From: Nicola Spencer on behalf of Planning.Responses
Sent: 18 December 2025 11:32
To: Planning Scanning
Subject: FW: LU/173/25/PL Arun Self Storage, Littlehampton

PL- Consultation- Highways response

Thank you for your email. It is understood that Arun District Council as local Planning Authority is not prepared to include a condition limiting vehicle movements. Some control is built in to the proposal as the number of spaces will be allocated to the HGV storage is restricted and the remaining spaces will be used as existing ie storage of caravans. In addition, the application is for storage and not for an operation use so naturally limits movements, therefore the Highway Authority would not raise an objection.

DRAWING BY	MB	DESIGN BY	-	CHECK BY	IR
DATE	17/10/25	DRAWING No.	6230 / 201	REV. No.	A
SCALE	1:500 @ A3

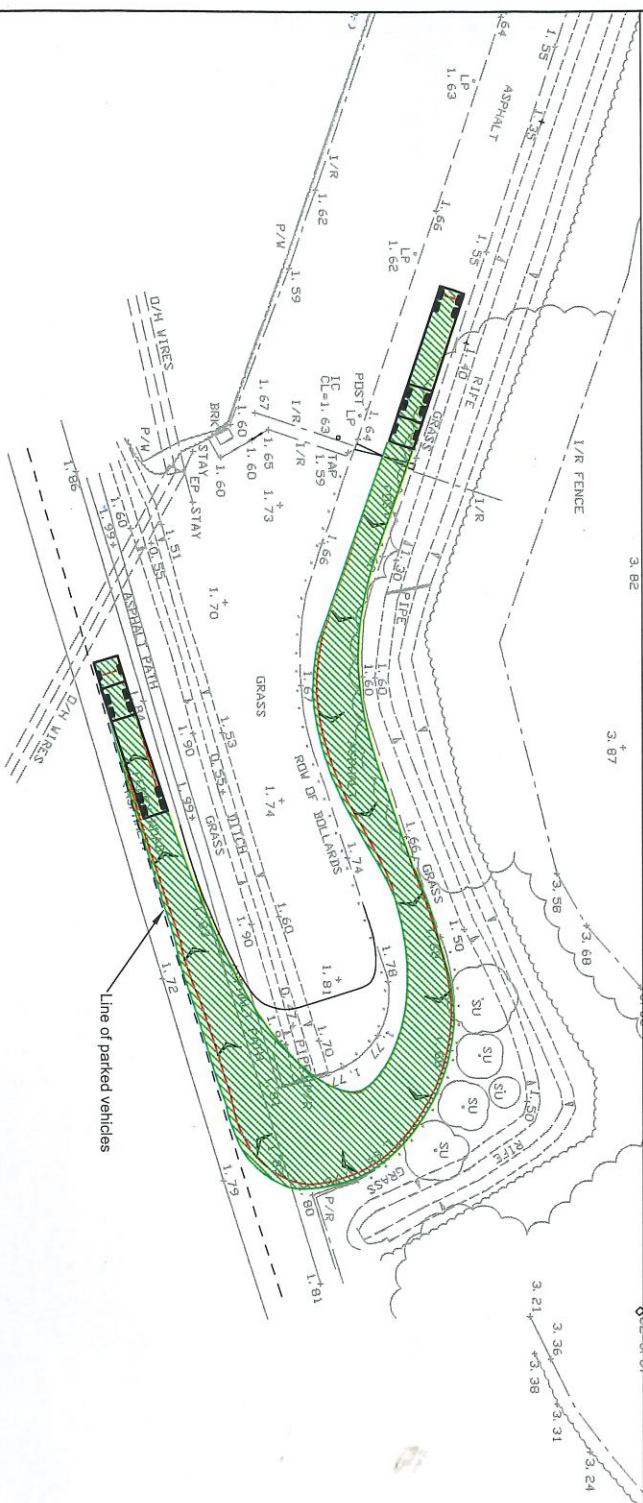
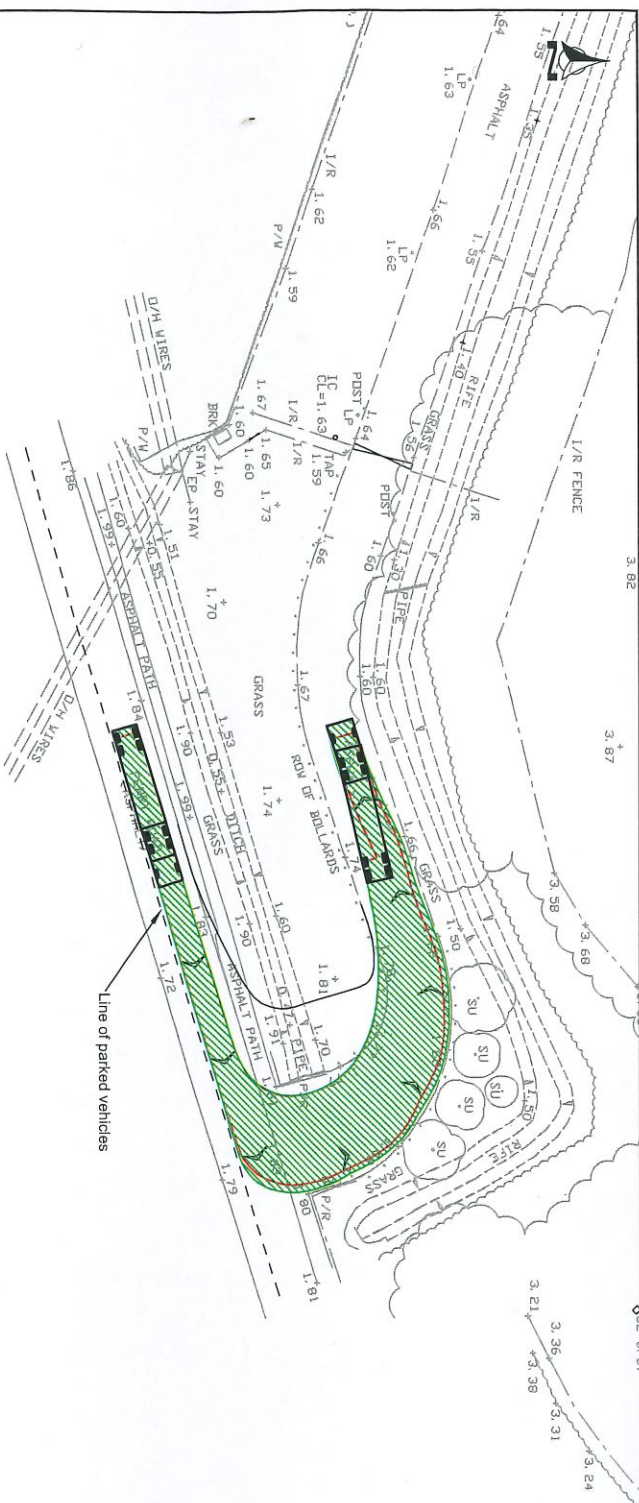
I've also requested the additional parking plan, as the one provided doesn't show the proposed parking arrangements. However, I'm unclear about your next request: a plan showing the widening of the access in relation to drainage has already been provided and is available online (document references LDC 6230/2001 and 6230/2002, attached). Is there any need for further details regarding the access way?
